Application No: BE/148/20/OUT

Site Address: Nursery Fields Land to the North of Chalcraft Lane West Bersted PO21 5TS

Description of works: Outline application for all matters reserved, with the exception of site access, to provide up to 225 residential units with associated infrastructure, open space and vehicular and pedestrian access. This application affects a Public Right of Way.

Thank you for your internet representation made on 15th January 2021 which has been recorded as no objection with the comments as follows:

SITE ACCESS PLAN (REF: ITB14244-GA-009)

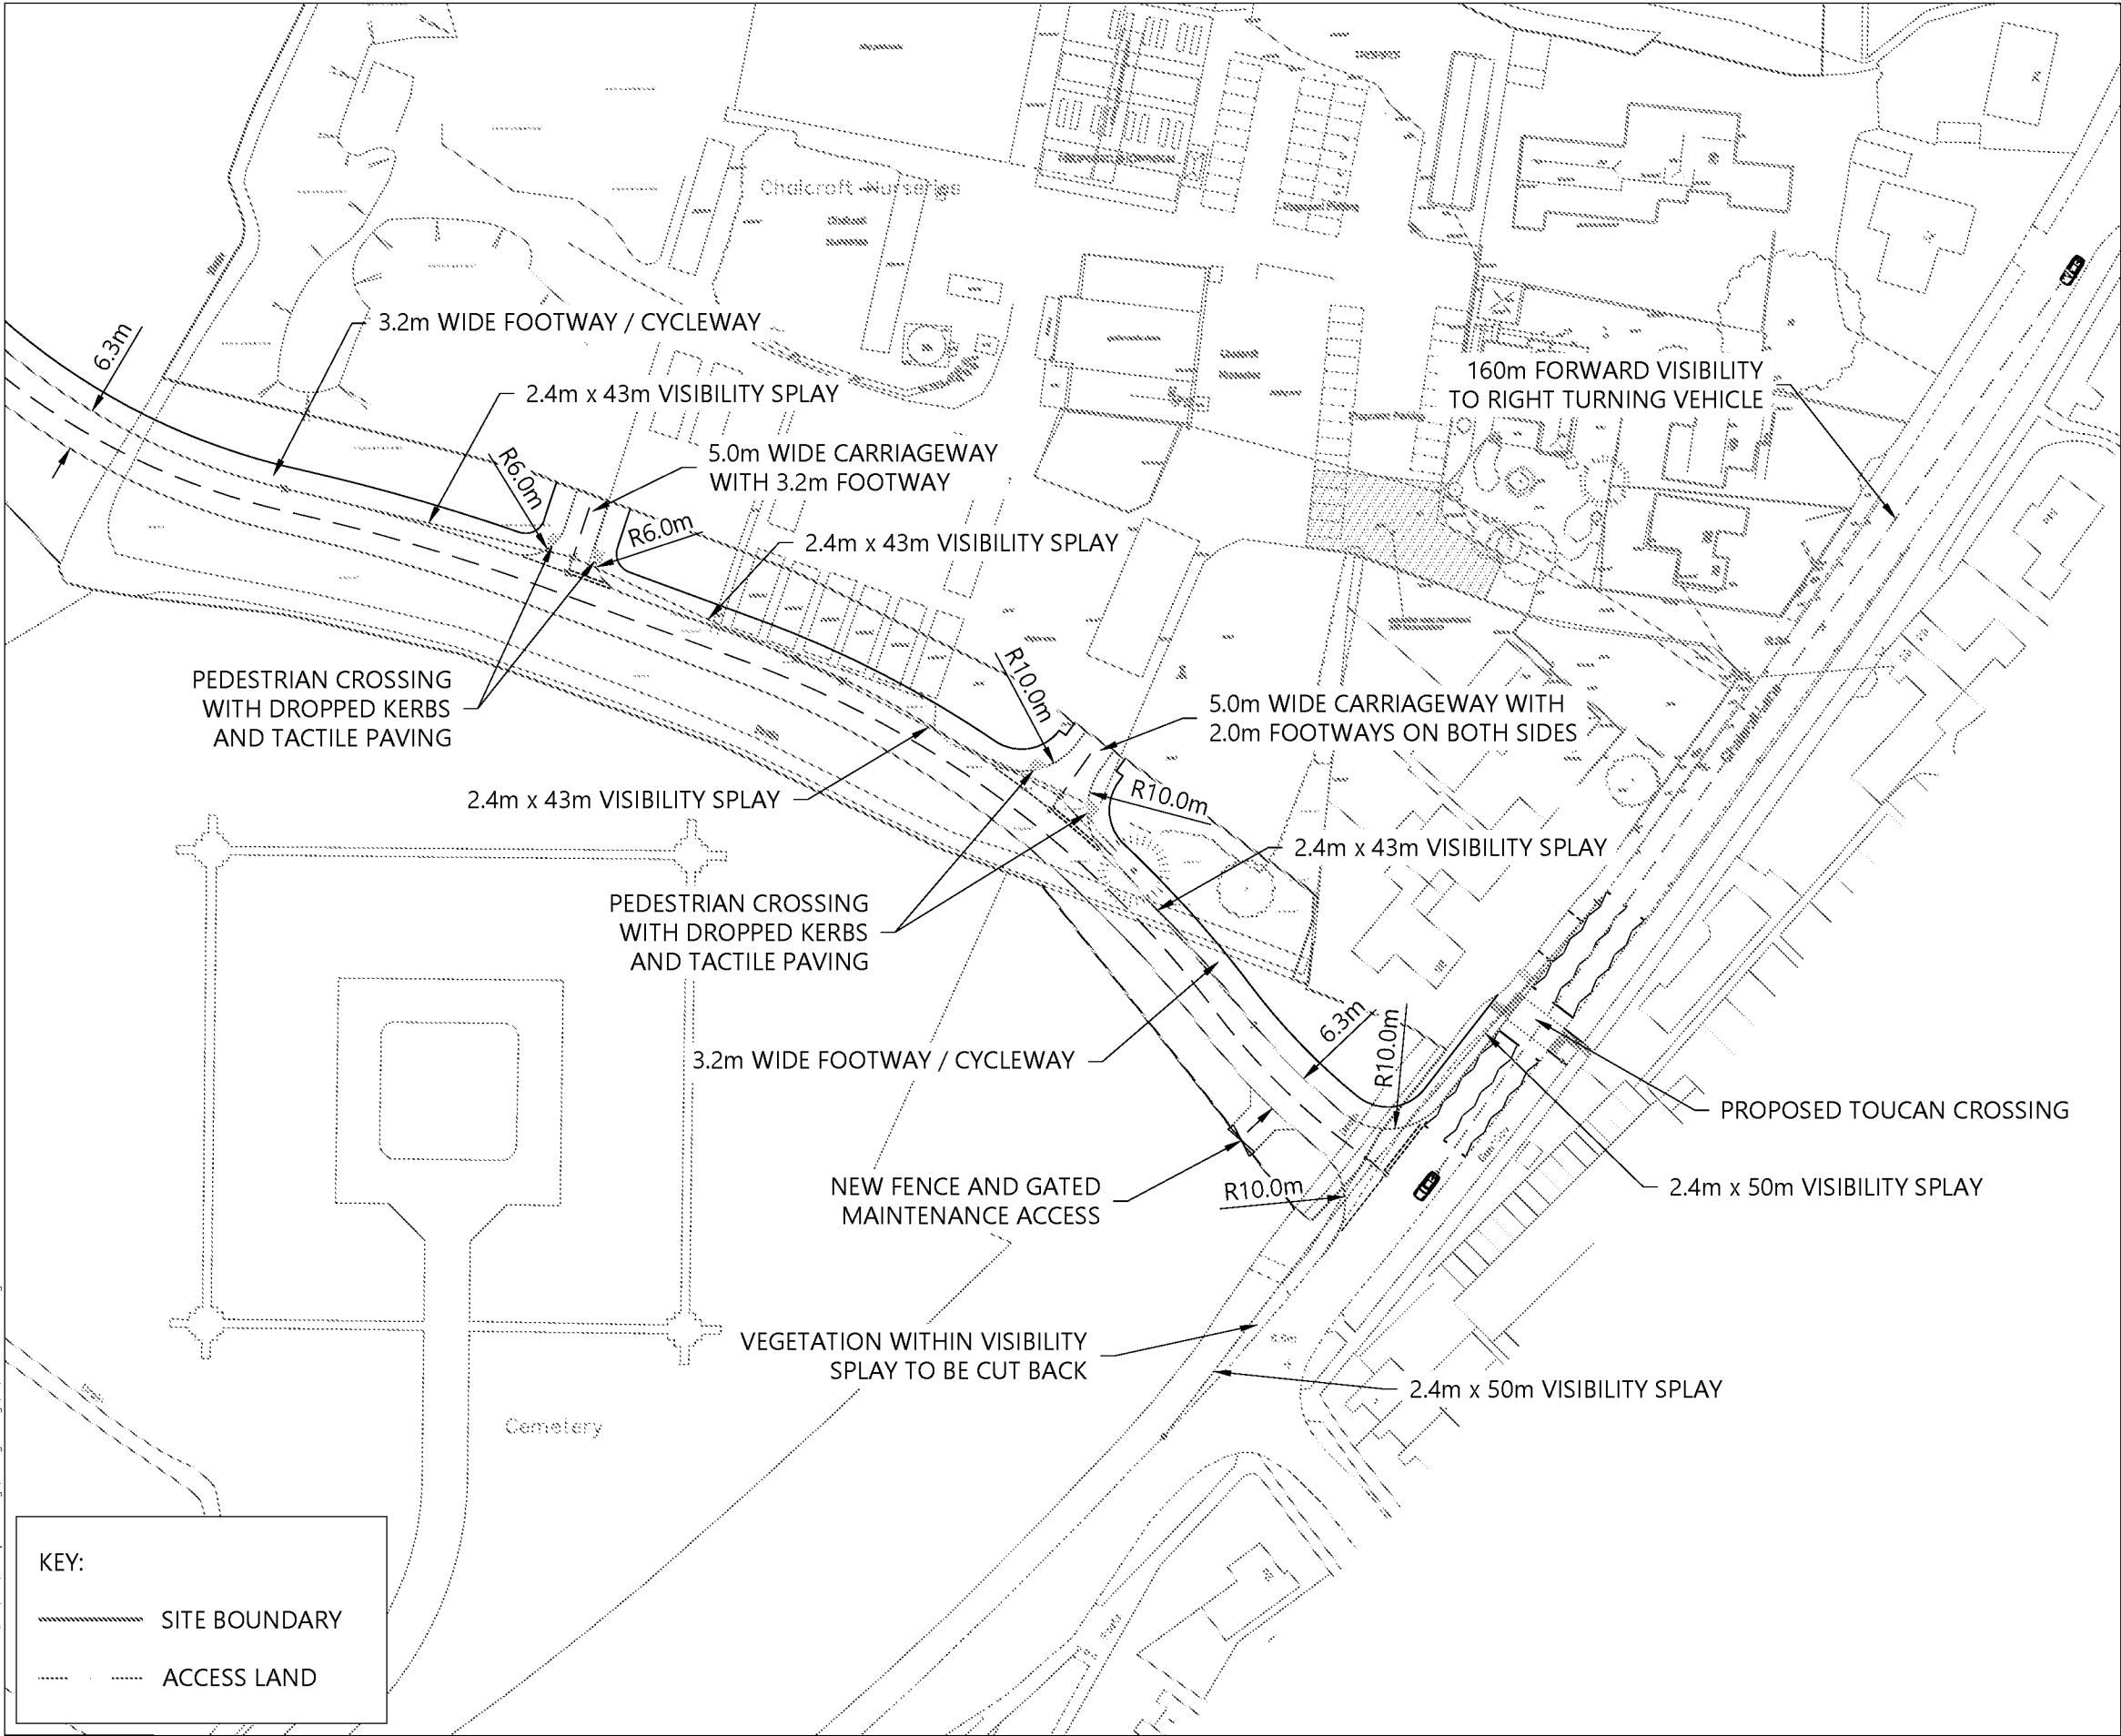
- The proposed access from Chalcraft Lane, shared with the application Chalcraft Nursery site BE/18/20/OUT, as a simple junction with no signal controls, is consistent with the West Bersted Framework Masterplan. Clarity is given in the Transport Assessment that traffic data collected in 2018 has been subject to an allowance for growth associated with committed development totalling 1,214 dwellings and 1,542 sqm of commercial development. Additionally, the TA states that whilst bus links and/or emergency vehicle access might be a future consideration for cross boundary connection, the proposed access has been designed to accommodate only the assessed vehicle numbers associated with the Nursery Fields application and that of Chalcraft Nursery BE/81/20/OUT.

- The Board notes the provision of pedestrian and cycle ways running parallel to the proposed access road.
- Given that the proposed access road is shared across two sites, the Board would encourage the applicant to work with the local planning authority and potential developers to ensure that the needs of pedestrians and cyclists are considered in the phasing of the construction cycle.

- The Board would encourage the early prioritisation of the proposed Toucan crossing installation to enable

safer use of existing pedestrian and cycleways along Chalcraft Lane during the construction phase.
